Ribble Valley Borough Council
Housing & Development Control

App. no: **3/2025/0801**

Address: **Land to east of Salesbury View Wilpshire**

Proposal: **Proposed erection of new residential development comprising 80 new homes, including 30% affordable housing, open space and associated infrastructure.**

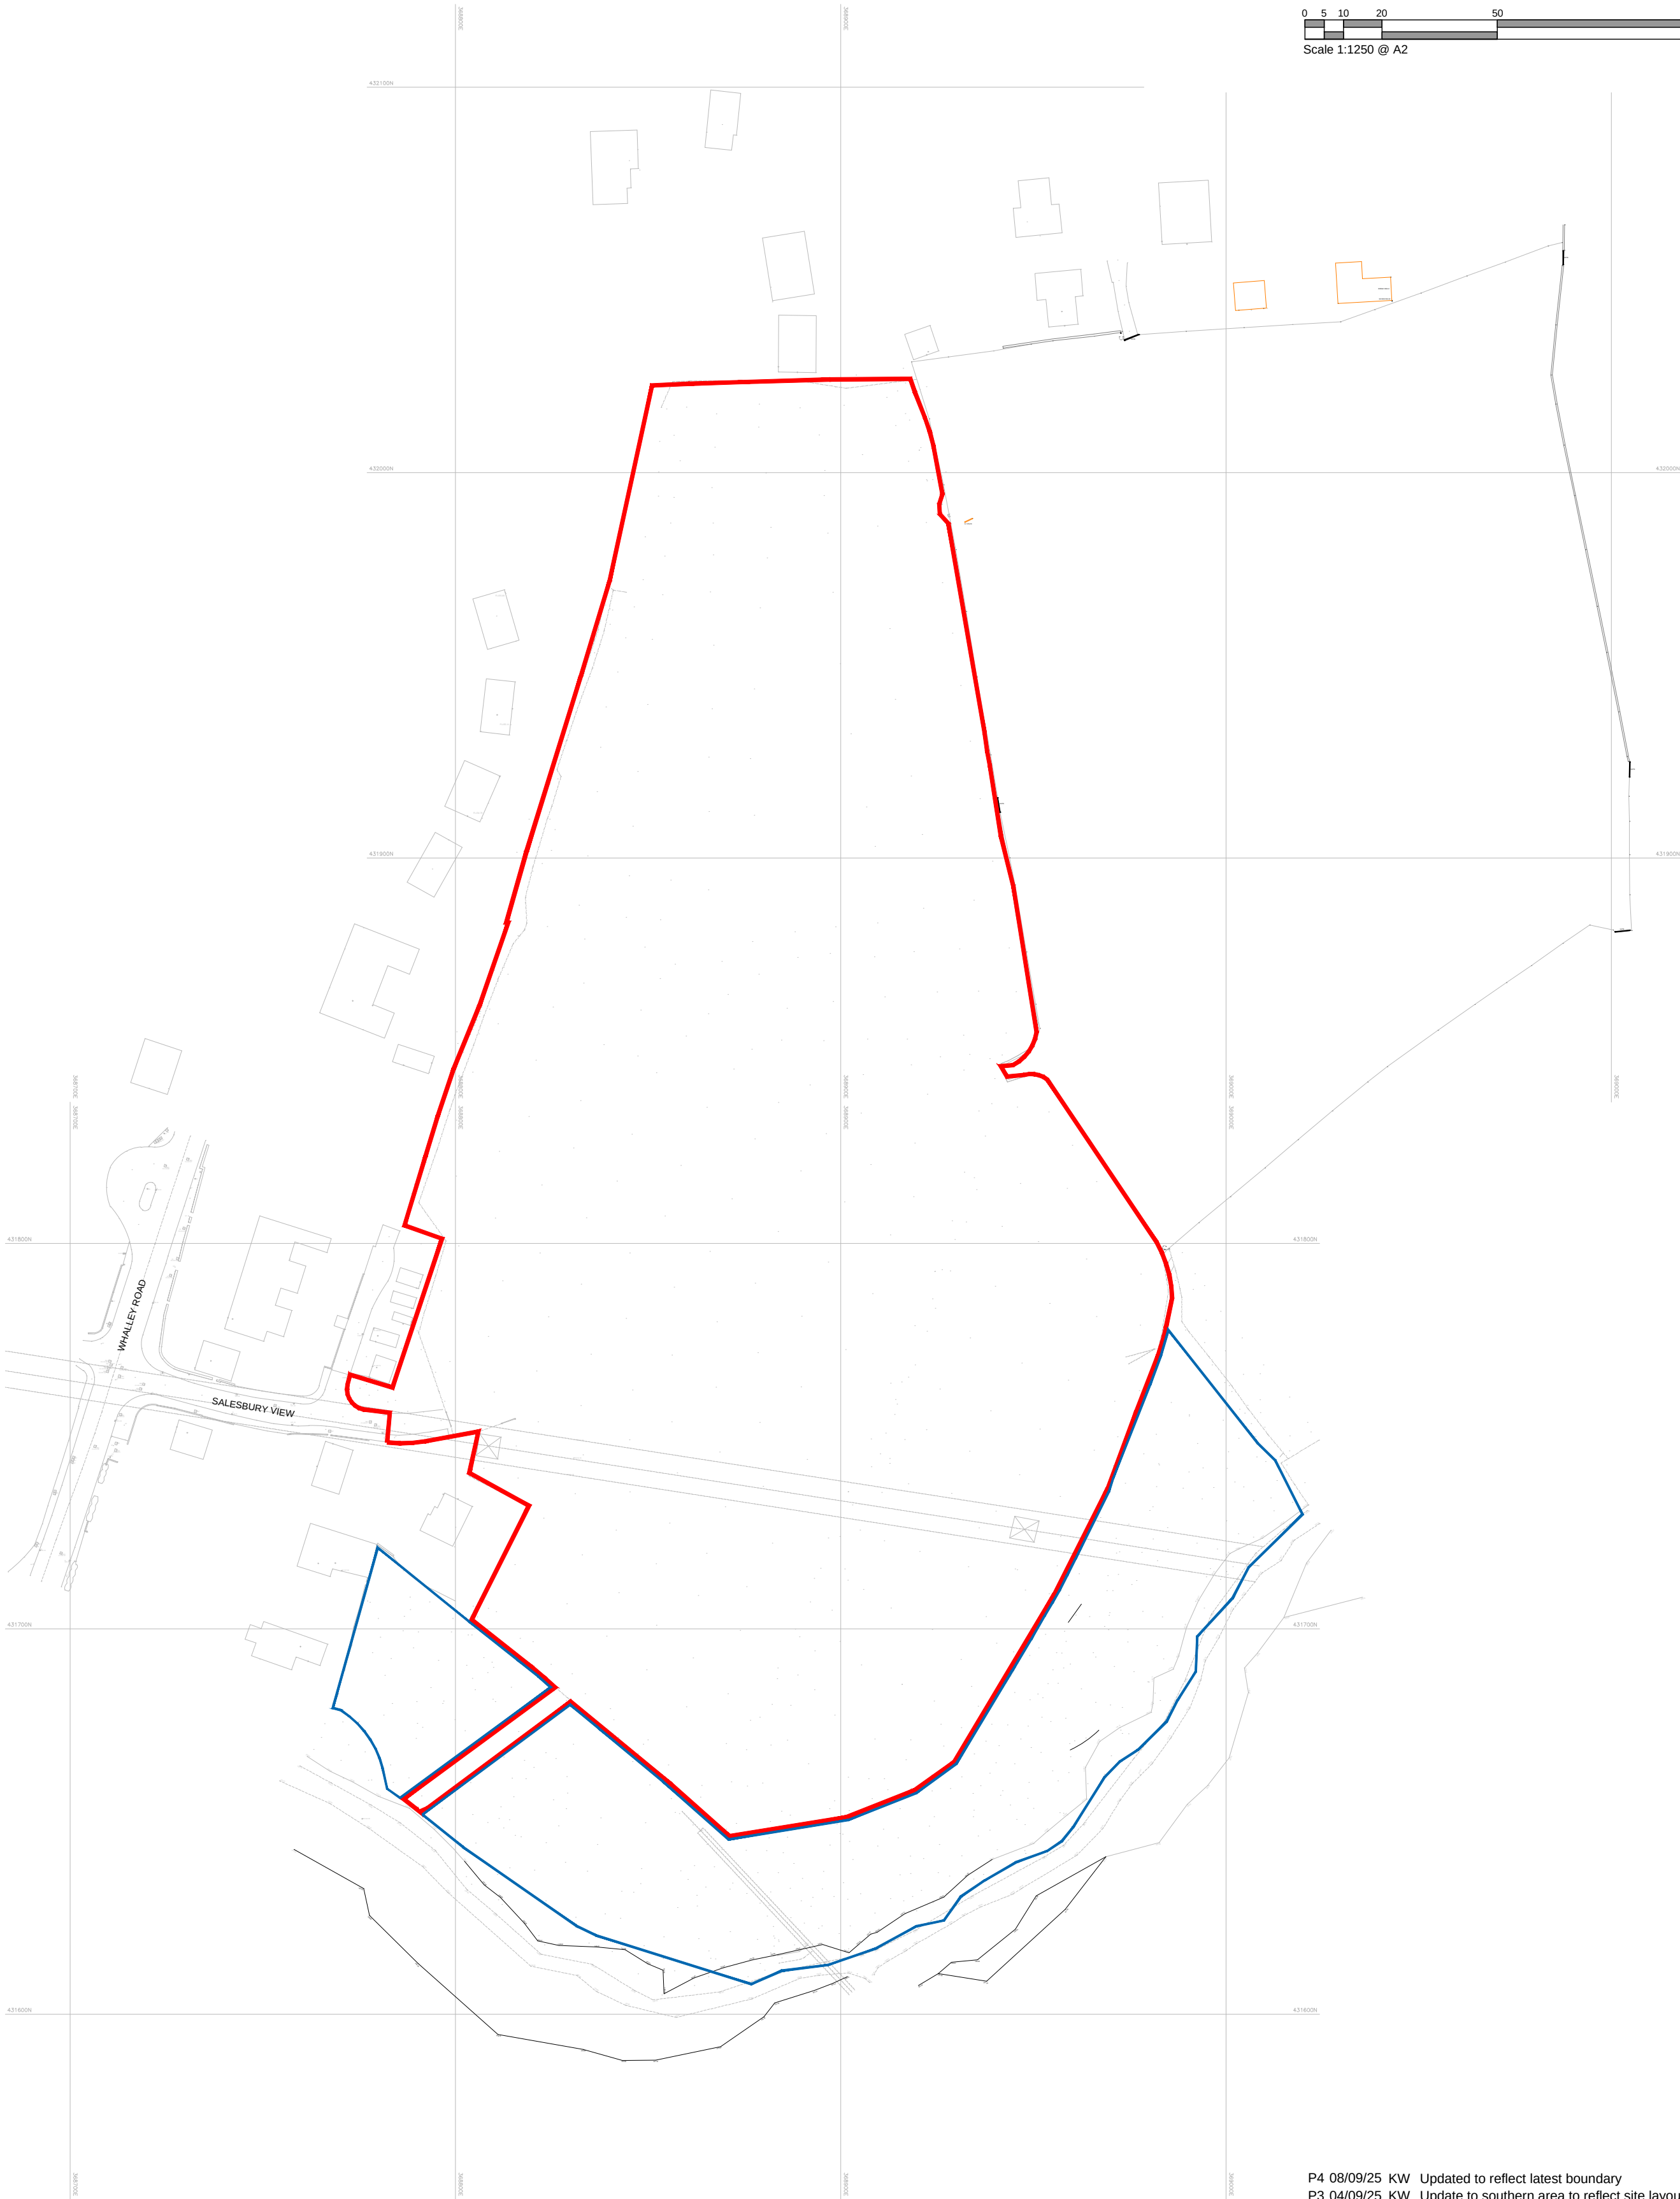
The updated idp 'Proposed site layout' 101-P25 includes a swale alongside public footpath FP0346025 and a change to the red edge which excludes the woodland area which is now in the blue edge. This results in a long section of footpath outside the red edge when it was previously within in.

As a result of the introduction of the swale, before works commence in that area, we would request an additional condition which requires a detailed design of the swale and the public footpath to be submitted to ensure that the ground/water levels and planting are suitable to ensure the safe movement of users of the public footpath.

We would request that the footway width is increased to minimum 1.8m outside plots 69-70. Subject to this the layout is to adoptable standards.

2. Prior to commencement of works to the swale adjacent to public footpath FP0346025 a detailed design of the existing and proposed ground levels, proposed water levels and planting shall be submitted for approval to the Local Planning Authority and shall be implemented thereafter in accordance with the agreed proposals. Reason: To ensure safe and suitable movement of pedestrians on the public footpath.
